## **Response to submissions – Minto Resource Recovery Facility (SSD 7462)**

This letter responds to the items raised in the *Bingo Resource Recovery Facility, 13 Pembury Road, Minto (SSD 7462) Request for Response to Submissions*, issued on 22 August 2017 and 14 February 2018.

A submission comprising a letter (dated 22 August 2017) was received from DPE. Several comments were provided and responded to in Table 1. Additional comments were provided via email on 14 February 2018. These additional comments have been incorporated and responded to within Table 1 below.

Swept Path Analysis and Vehicle Stacking Plan

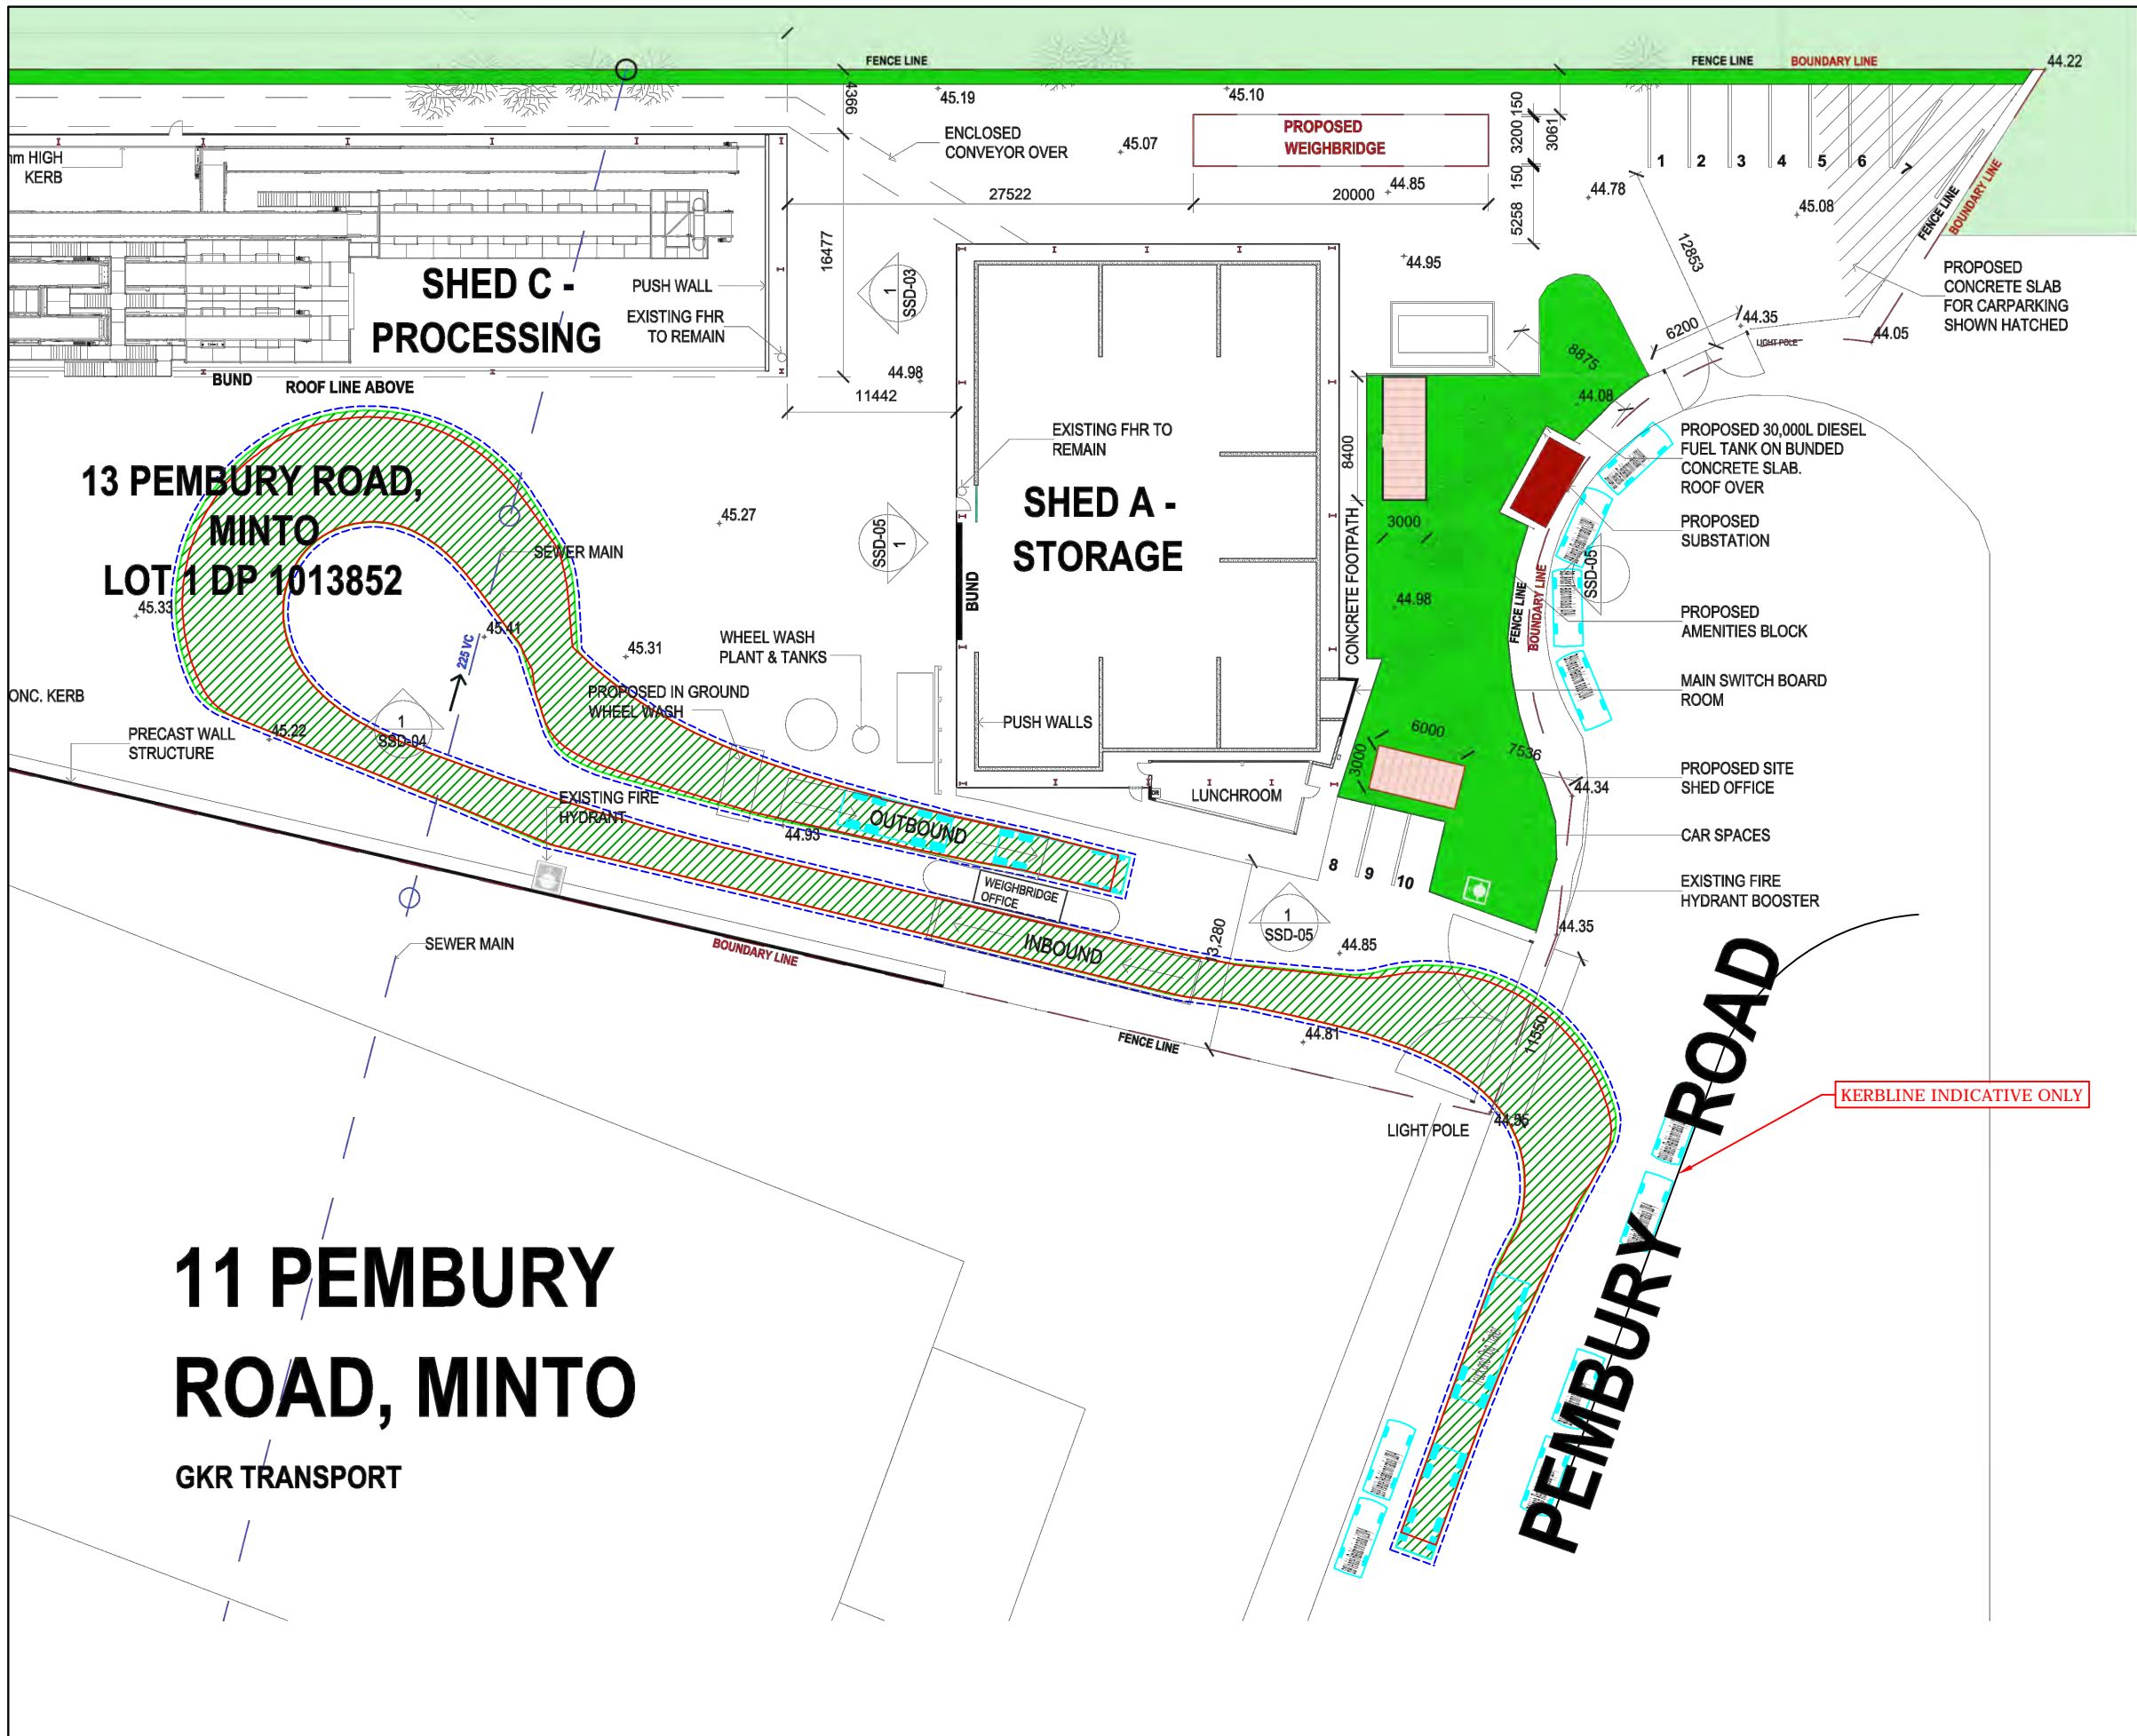
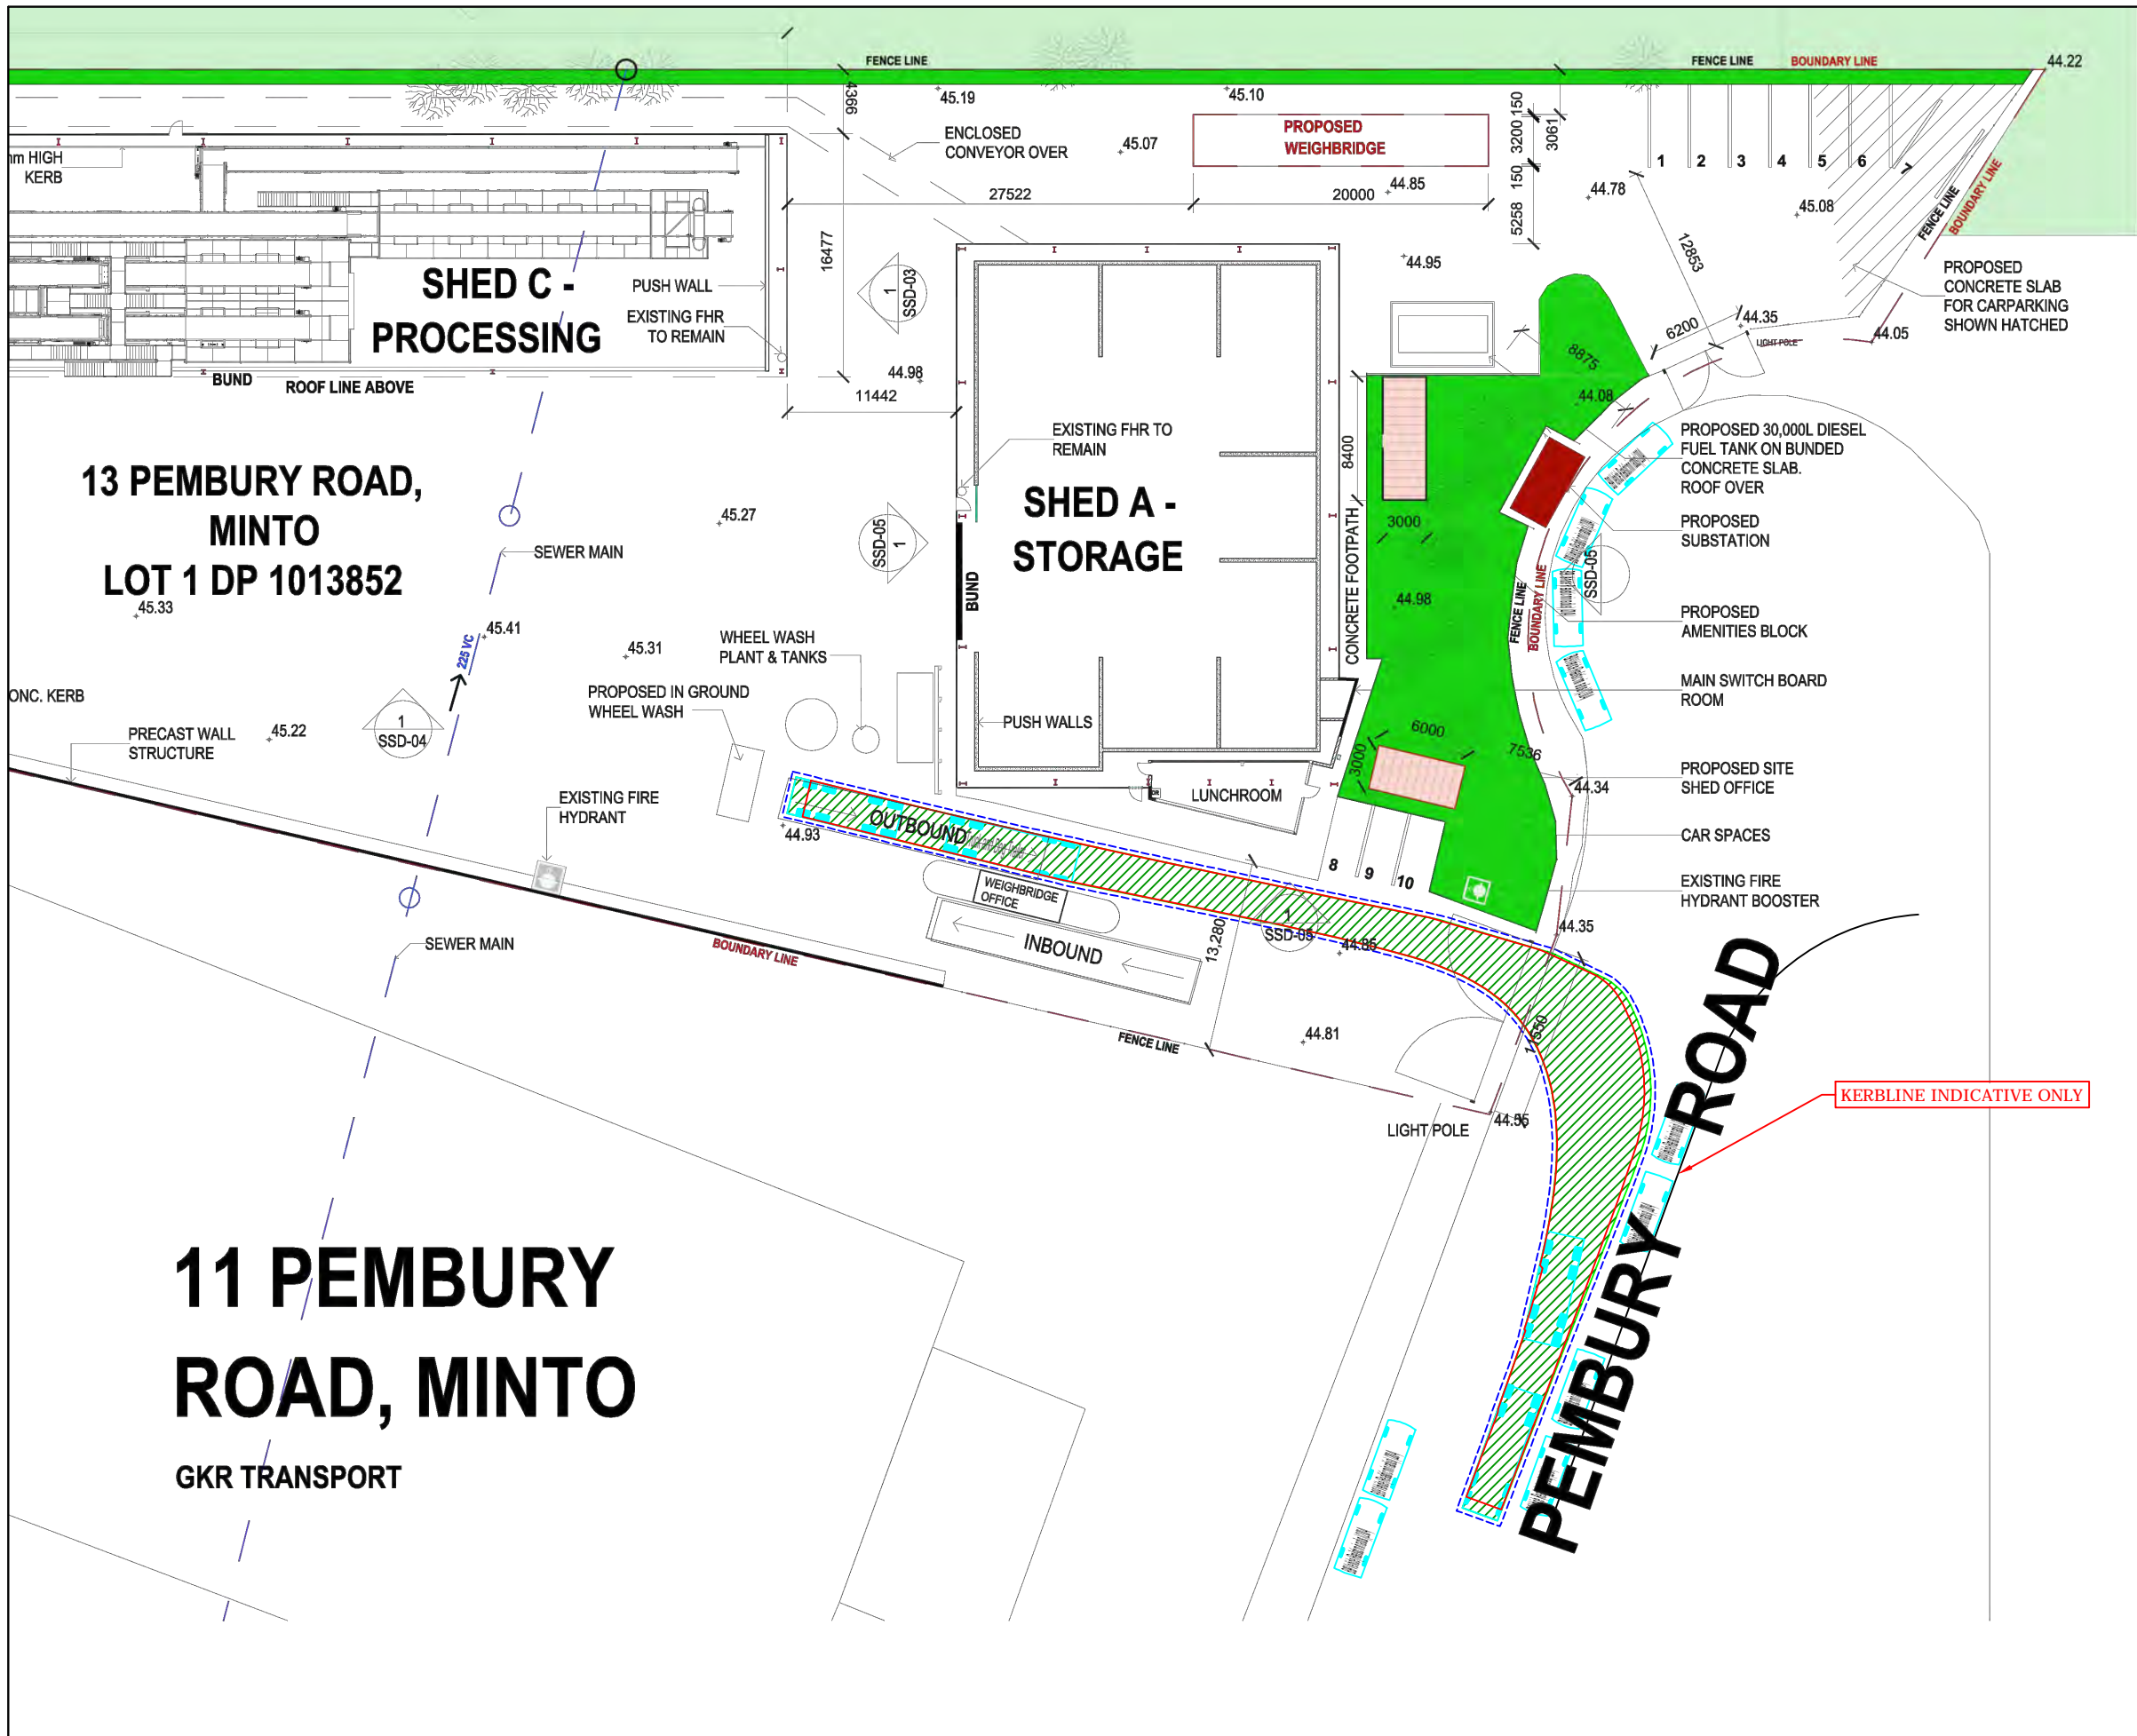
Provide plans showing the swept paths of the front-end loader proposed to be used to move waste on-site and vehicles used for waste collection. The plans should include the stacking of vehicles within the site to demonstrate there is sufficient space onsite at peak periods.	<p>As noted and described in Section 6 of this RtS a number of amendments have been made to the Proposal following the exhibition of the EIS in response to submissions received. These include amendments to further optimise the internal site layout and improve safety (demonstrated by amended swept path analysis) for vehicle movements within the Proposal site, including removal of minor internal walls and cladding. It is proposed to remove the northern wall of Shed C to ensure optimal swept paths can be achieved by heavy vehicles safely and efficiently.</p> <p>Movement of the excavator between Shed A and Shed C has been considered while assessing the site layout. The key movements for the excavator are as follows:</p> <ul style="list-style-type: none"> <li>When there would be a waste collection truck loading-up adjacent to Shed A, the excavator would complete short movements between the waste storage bays within Shed A and a truck parked alongside Shed A.</li> </ul>	Section 6 of the RtS Addendum TIA (Appendix I of this RtS)
